Application by National Grid Electricity Transmission Plc for an Order granting Development Consent for the Richborough Connection Project

Planning Inspectorate Reference No: EN020017 Richborough Connection Project

**SEW's Comments on the Movement of PC10
UPDATED NOTE FOR DEADLINE 9**

**SECTION E-E**  
BETWEEN PC9-PC10

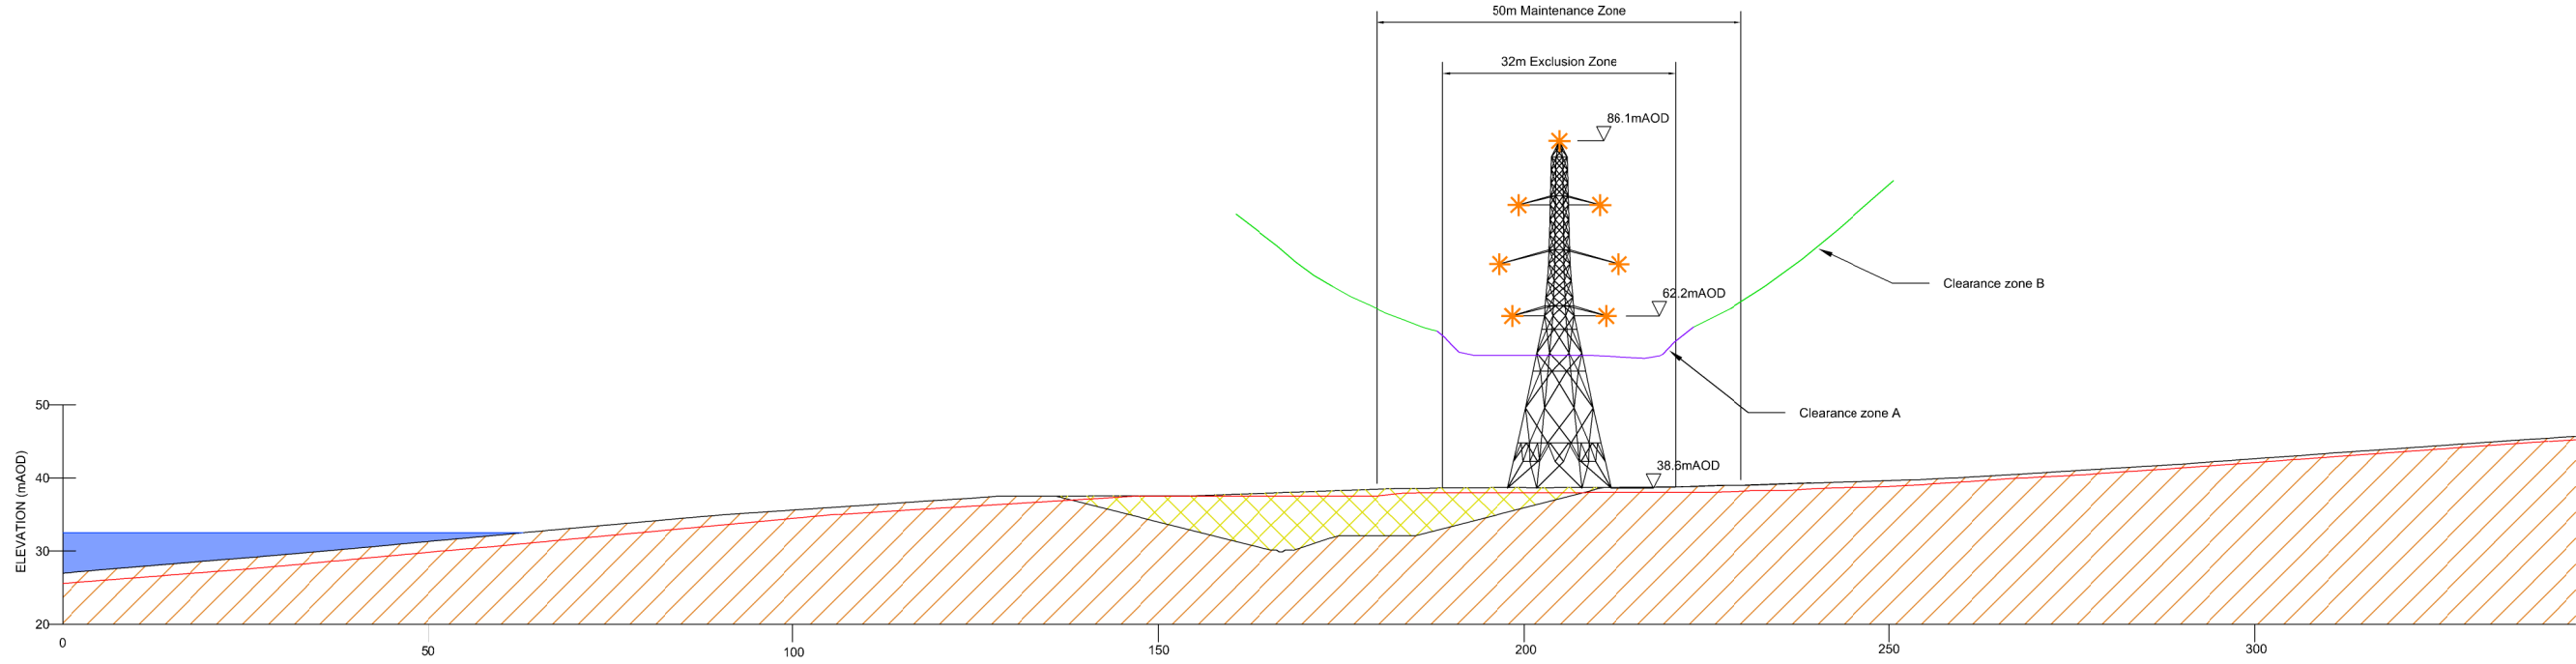
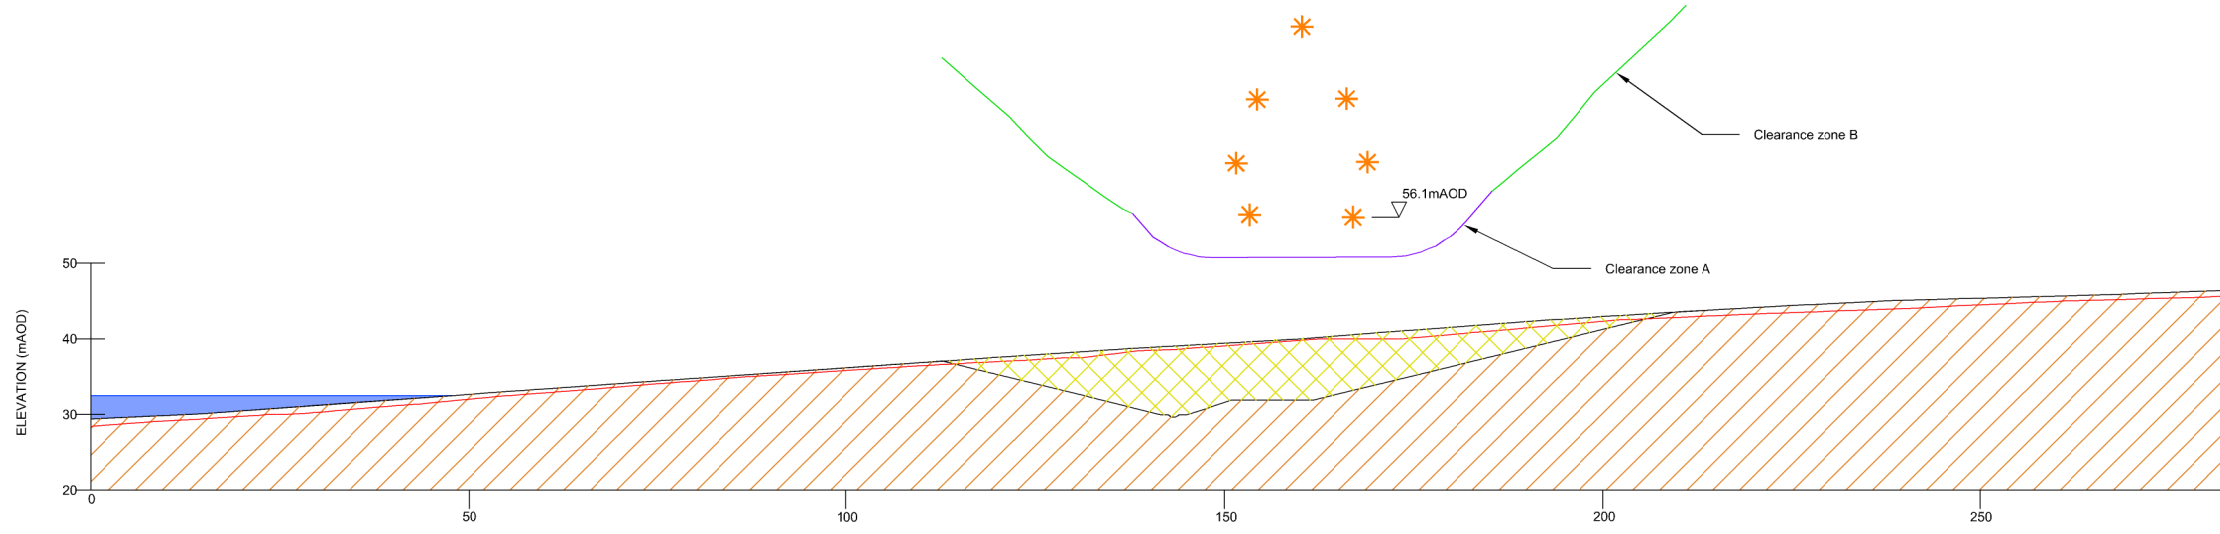
- 11 The tree clearances between PC9 and PC10 are reduced, as detailed below. In summary, clearances for options 5 -7 are reduced. The impact on the clearances is the same for option sets a) and b). Therefore, the detailed clearance heights information shown on the PC10 Spot Height Plans and data tables submitted at Deadline 7 by SEW REP7-035 are applicable to both option sets a) and b).
